4 October 2017

File No: SSD 6513 MOD 3
Our Ref: R/2014/14/E

RE: BUILDING R1, BARANGAROO SOUTH – SSD 6513 MOD 3

Ground Level Plan

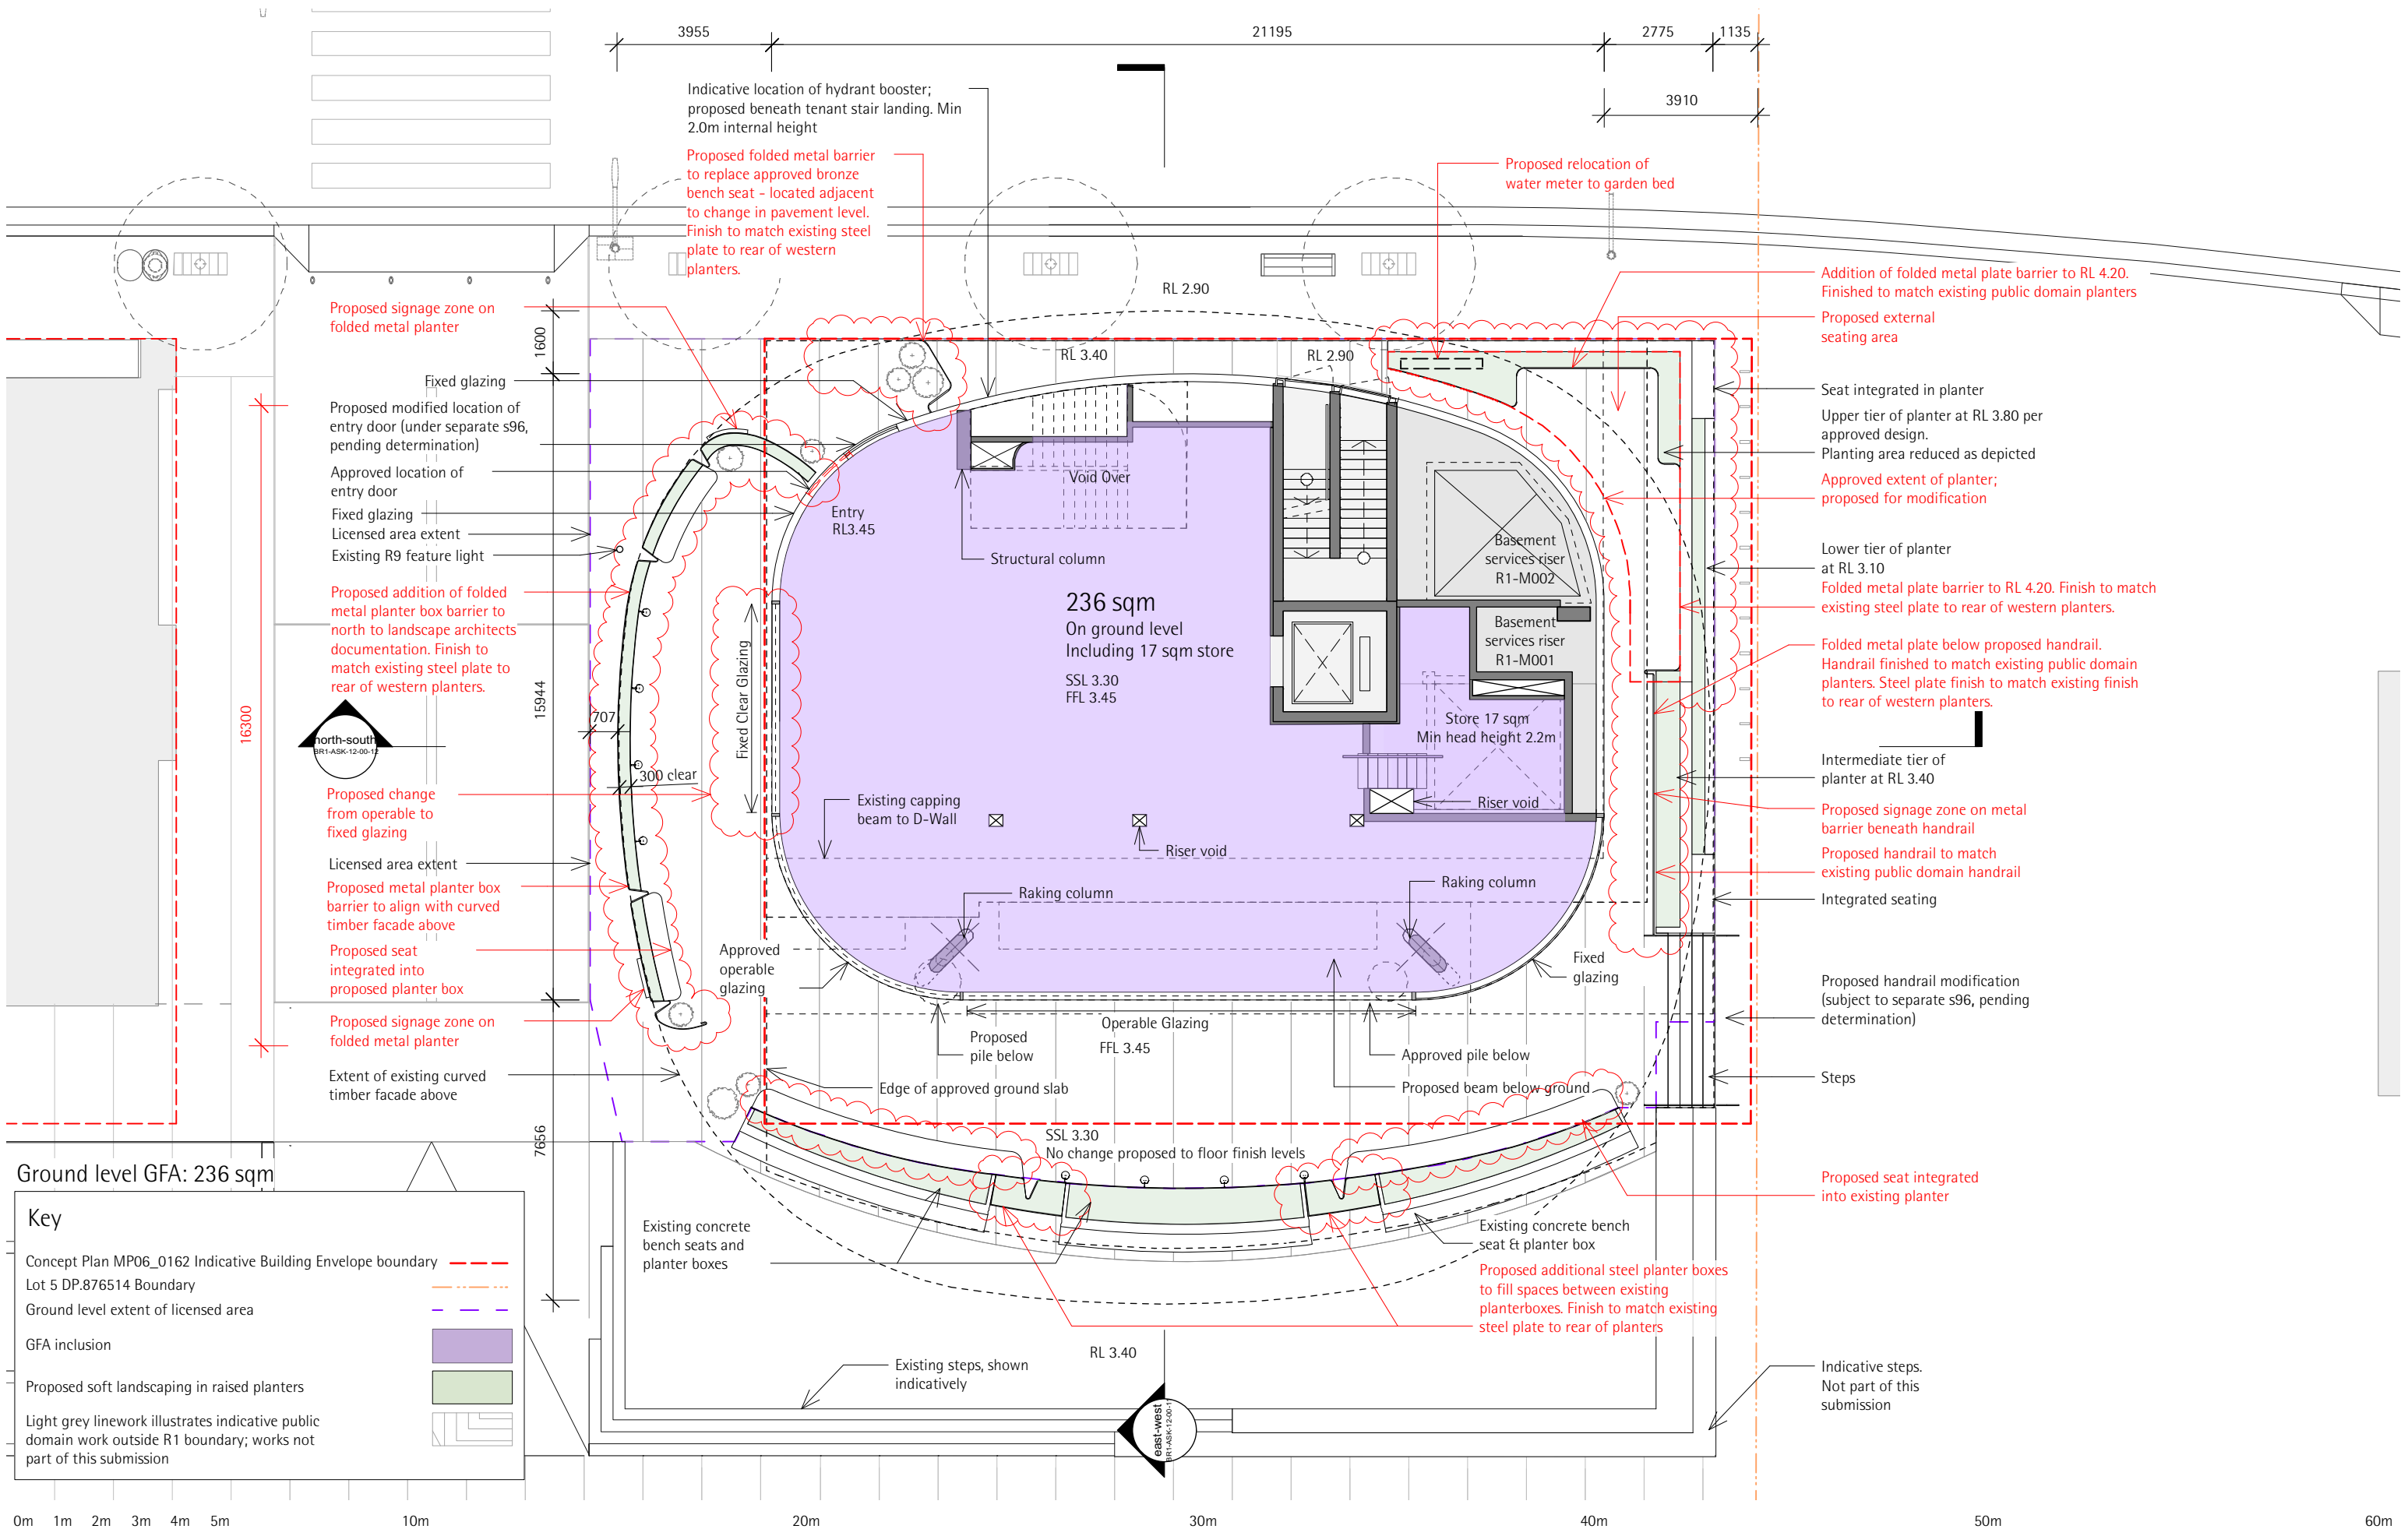
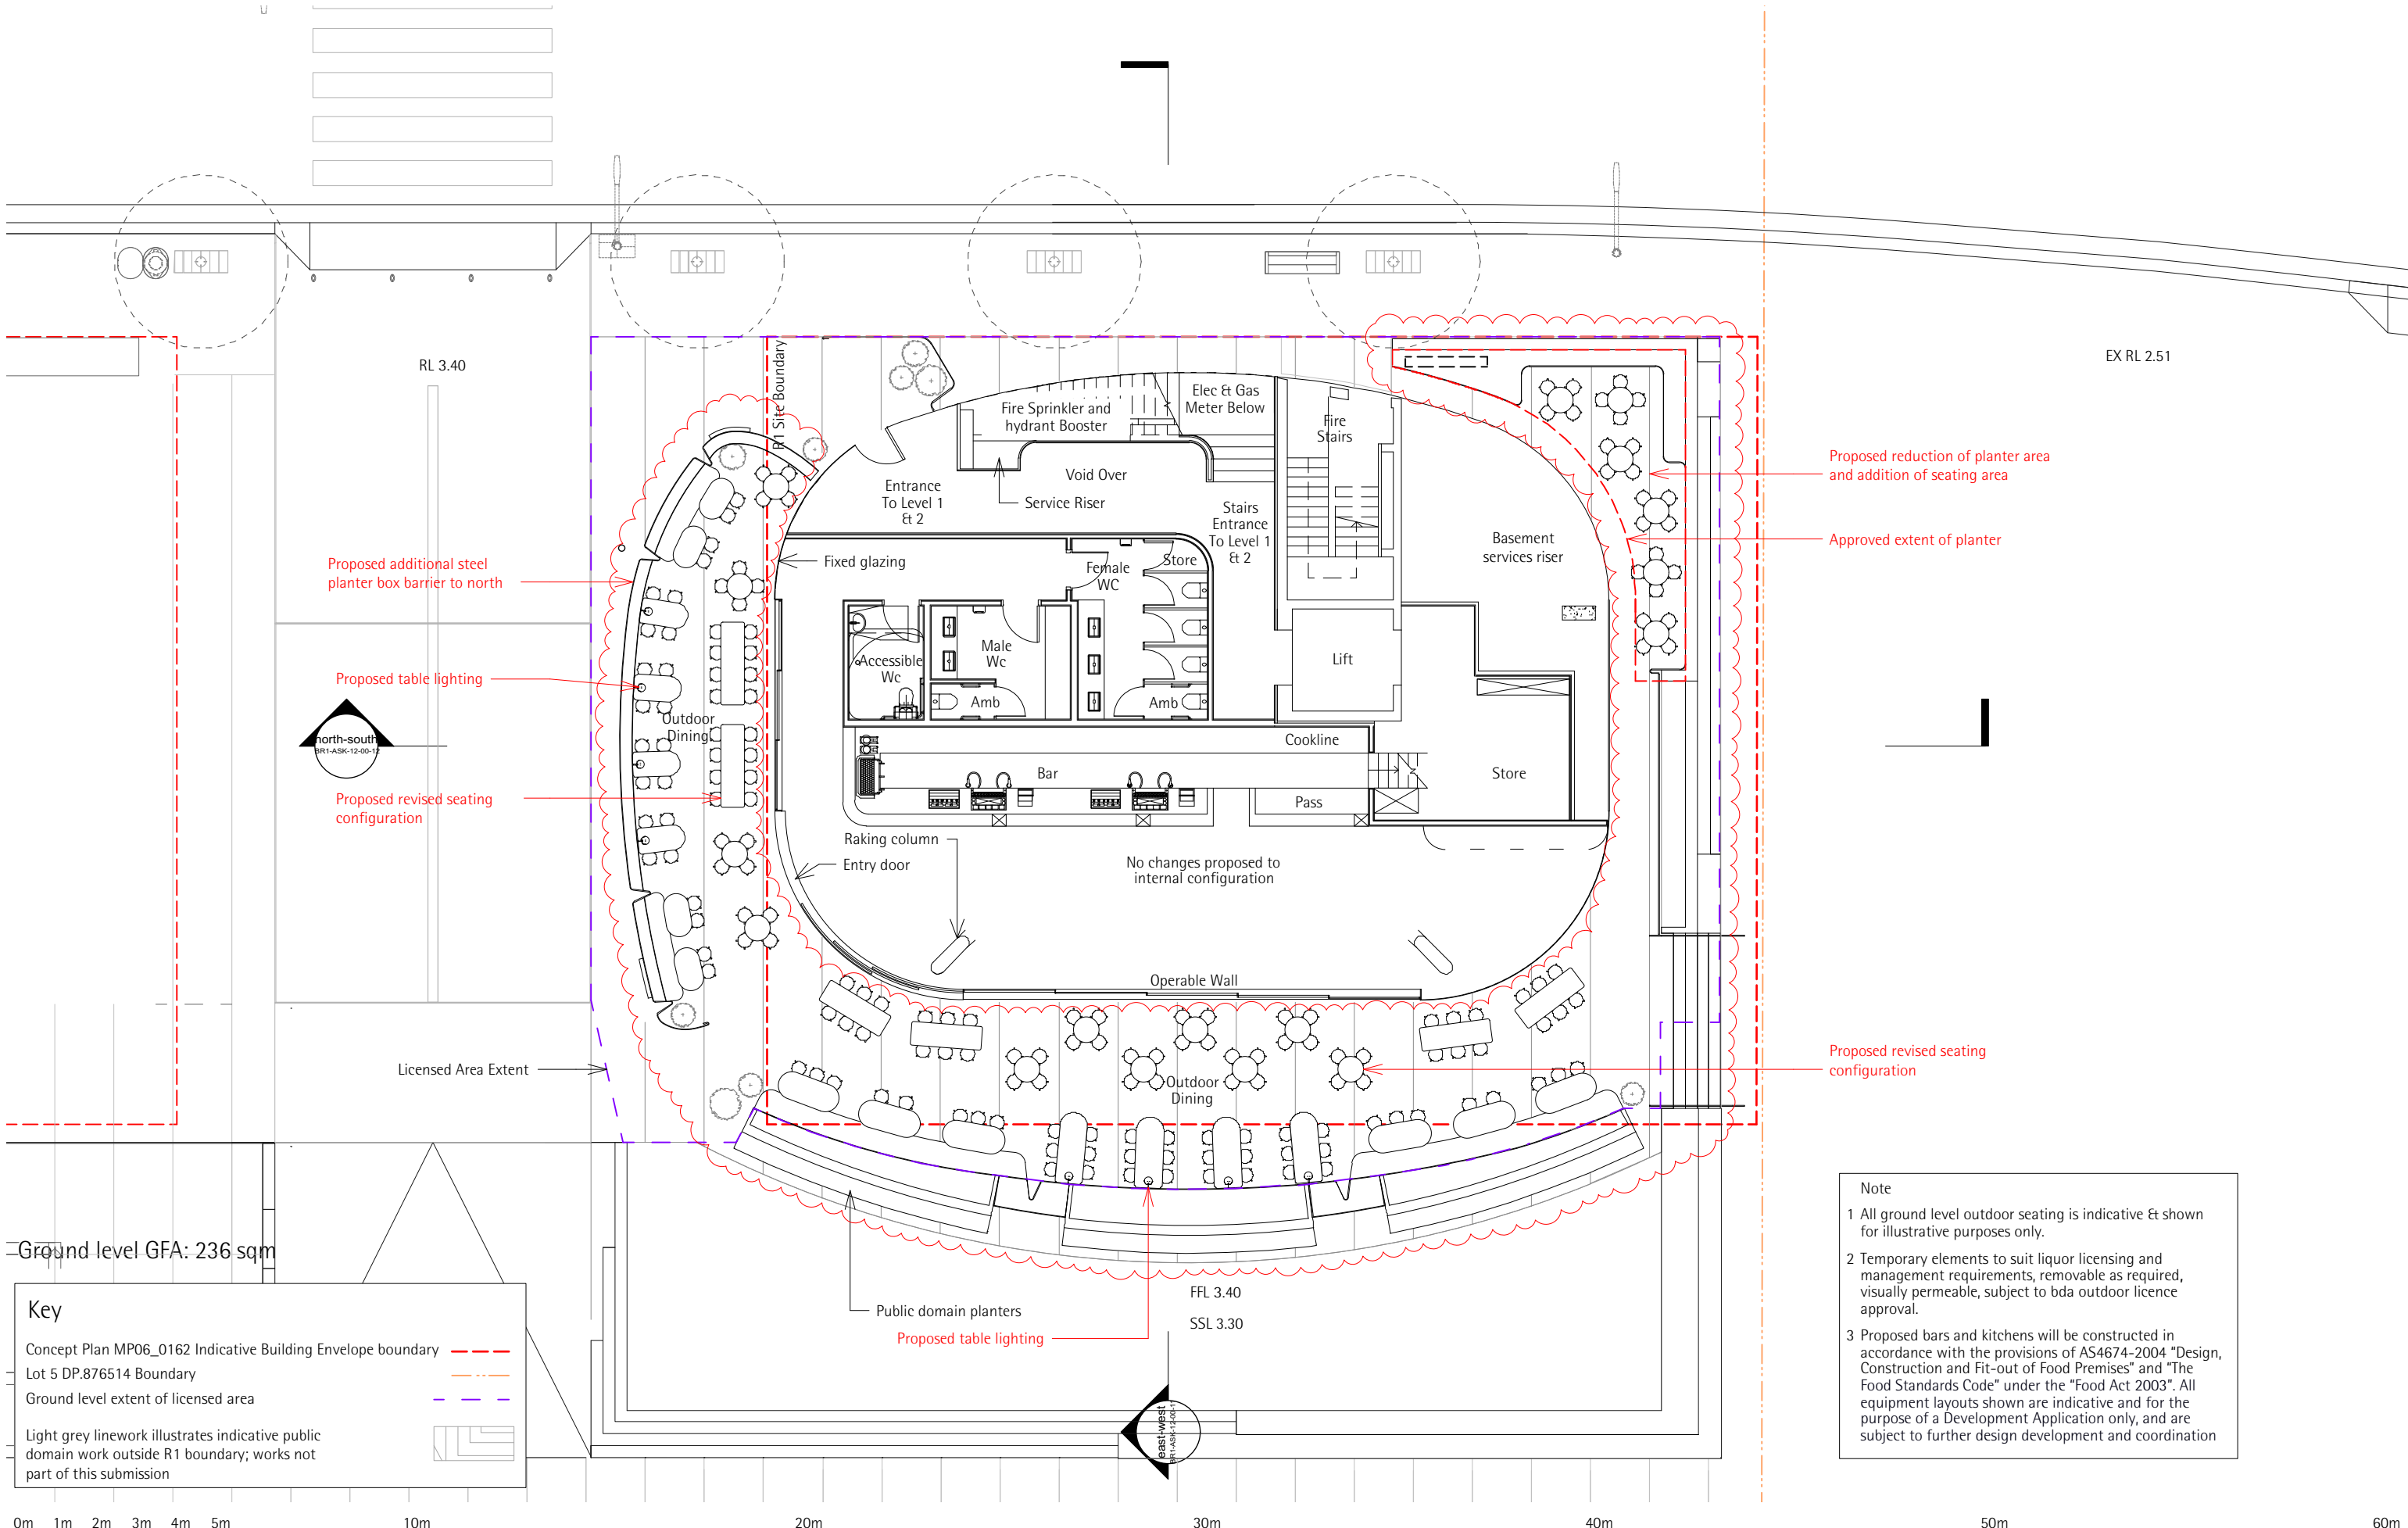
Concern is raised that this proposed new outdoor licensed seating zone in the south-eastern corner is in an isolated part of the building, located behind a service area, ‘disconnected’ from the public areas of the “pub”. Given the approved use of the building as a “pub”, the visual and physical separation from the premises proper limits the ability of staff to properly managed patrons within this space. It is also evident that ‘Crime Prevention Through Environmental Design’ principles have not been thoroughly considered as part of this proposed modification.
